MAINE MEDICAL CENTER BEAN 2 ROOF PROJECT

Site Plan Application / Supplemental Submission
22 Bramhall Street
CBL 53-D1,2,7; CBL 53 -E-1,2,10,13; CBL 53-G-1,13; CBL 54-H-I;
CBL- 64-C-1,2

Maine Medical Center is pleased to submit the following responses and updated materials to assist your review of the Bean 2 Roof Addition Site Plan Application. These responses are based upon continued review by staff. As you are aware we have submitted twenty six (26) exhibits/ tabs to date, therefore, this submission adds new exhibits/ tabs as noted herein:

I. ADDITIONAL REQUEST FOR INFORMATION, EMAIL FROM JEAN FRASER DATED JUNE 21, 2013

D4 OVERALL NORTH ELEVATION
1/8" = 1'-0"

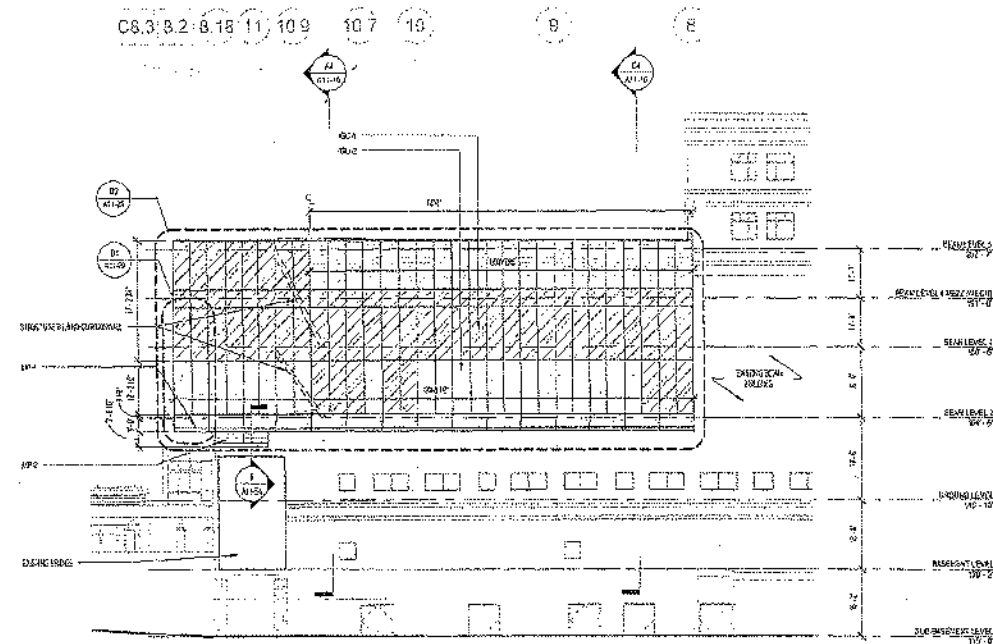
Rendering that shows reflectivity of louvres and metal panels (accurately in comparison with the glass/fritted glass) on the north elevation.

The new metal panels will match the existing panels installed on the East Tower. MMC would be happy to arrange a site visit for the City Planning Board members and/or staff to review this material. Perkins + Will, project architects, will be bringing a sample of the metal material as well as fritted and spandrel glass samples to the Public Hearing. We believe that these approaches will provide a more accurate representation of the materials being used than any rendering could achieve.
